**Byers Gill Solar**  
**EN010139**

# 8.12 Comments on Deadline 2 Submissions including Written Representations and Responses to ExQ1

Deadline 3 – September 2024

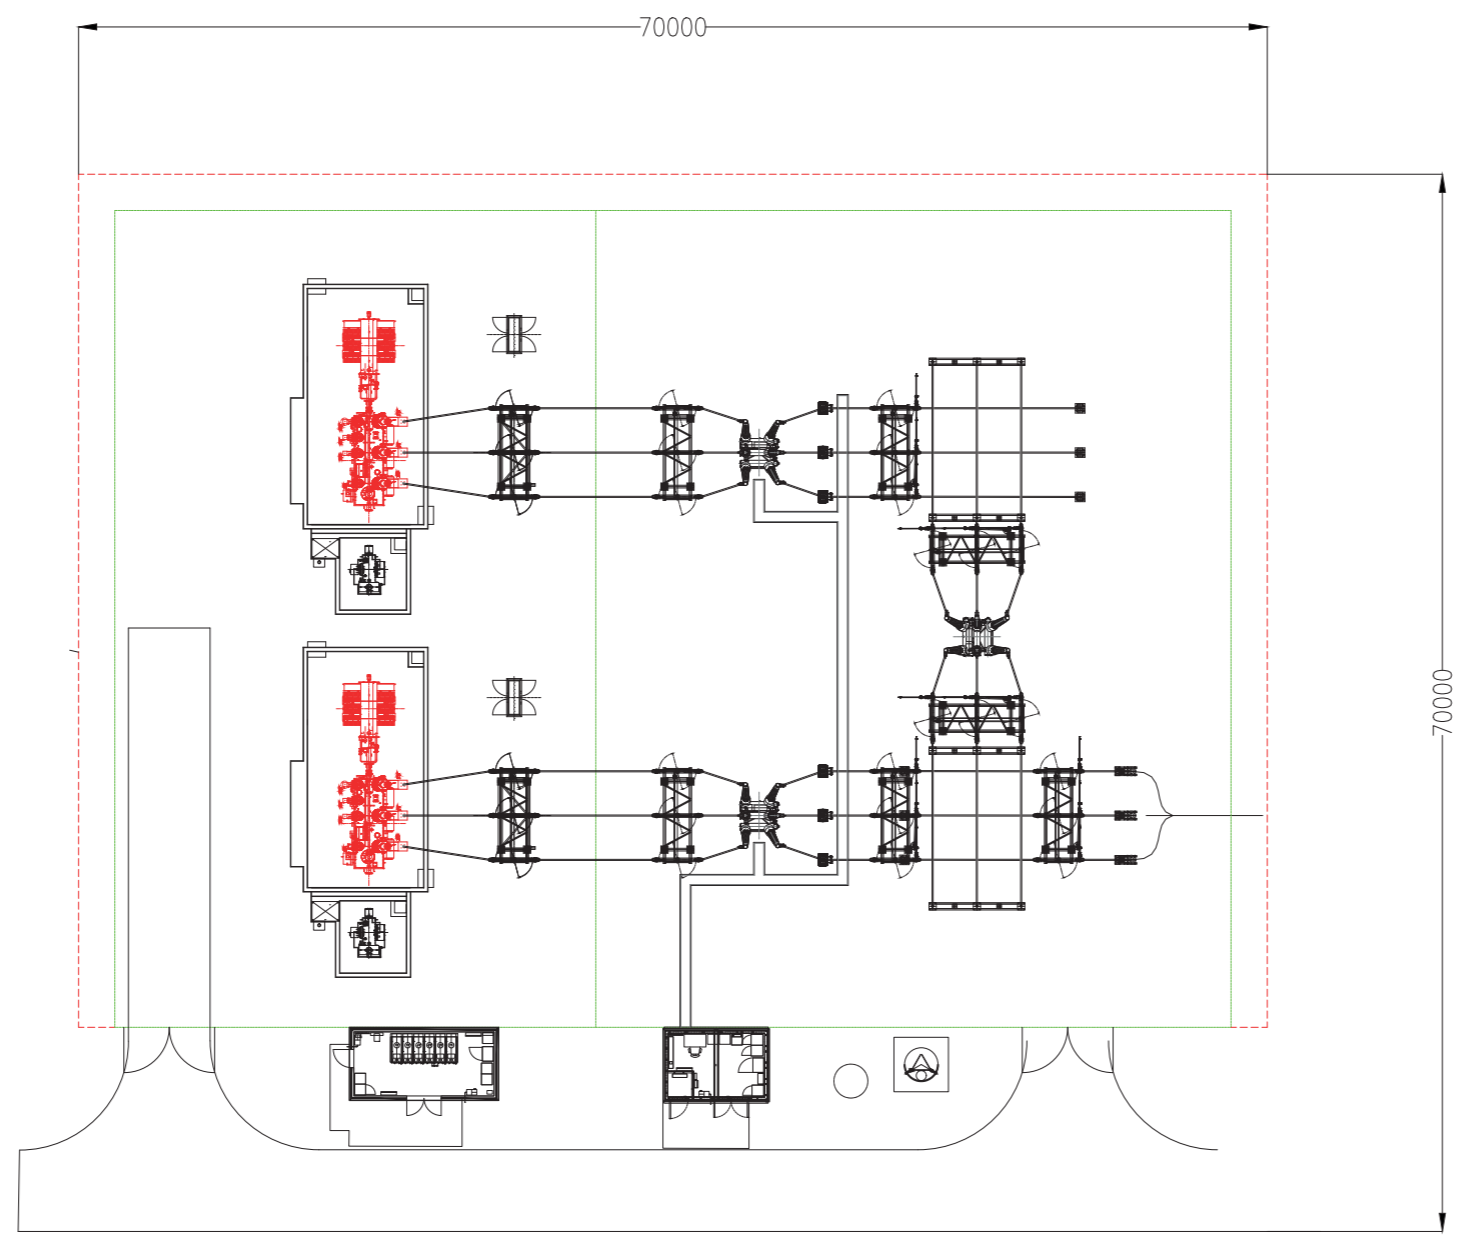
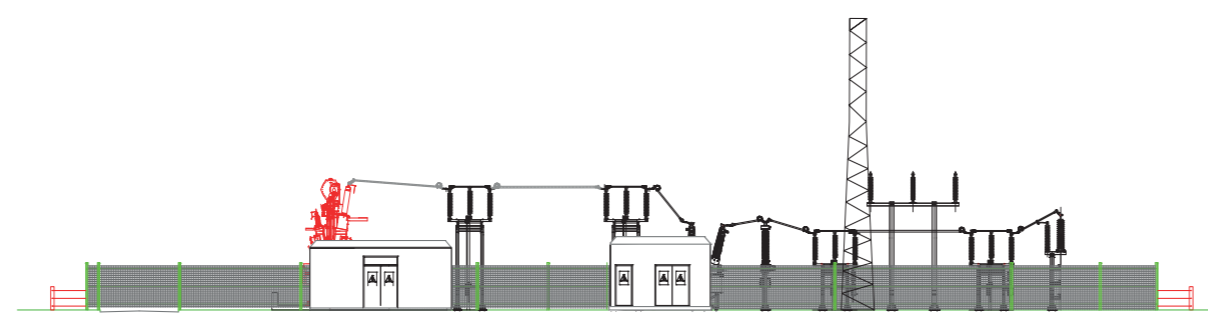
- 4.2.18. *“Design features including a 15m high structure are described as causing little effect – the Parish Council can think of no 15m high structure in a rural area that has no visual or environmental effect. Has RWE given detailed prospective elevations of planned structures and firm proposals of their location?”*

- 4.2.19. It should be noted that the only element of the Proposed Development which would be 15m high is one communications mast which will be located at the on-site substation. The location of the on-site substation within Panel Area C is shown on various plans and drawings including ES Figure 2.2 Revision 2: General Arrangement Scheme Wide [REP2-015] and ES Figure 2.5 Revision 2: General Arrangement Panel Area C [REP2-018]. The design parameters, including the maximum height, of the substation and mast is set out in Table 8-1 of the Design Approach Document [AS-004].

- 4.2.20. Both the substation and the communications mast will be reasonably well screened on many sides by Square Wood and newly proposed planting, as described in ES Chapter 7 Landscape and Visual [APP-030]. The vast majority of the Proposed Development would be much lower lying, with panels being no more than 3.5m in height and the containers which house the inverters and batteries being no more than 3m in height.
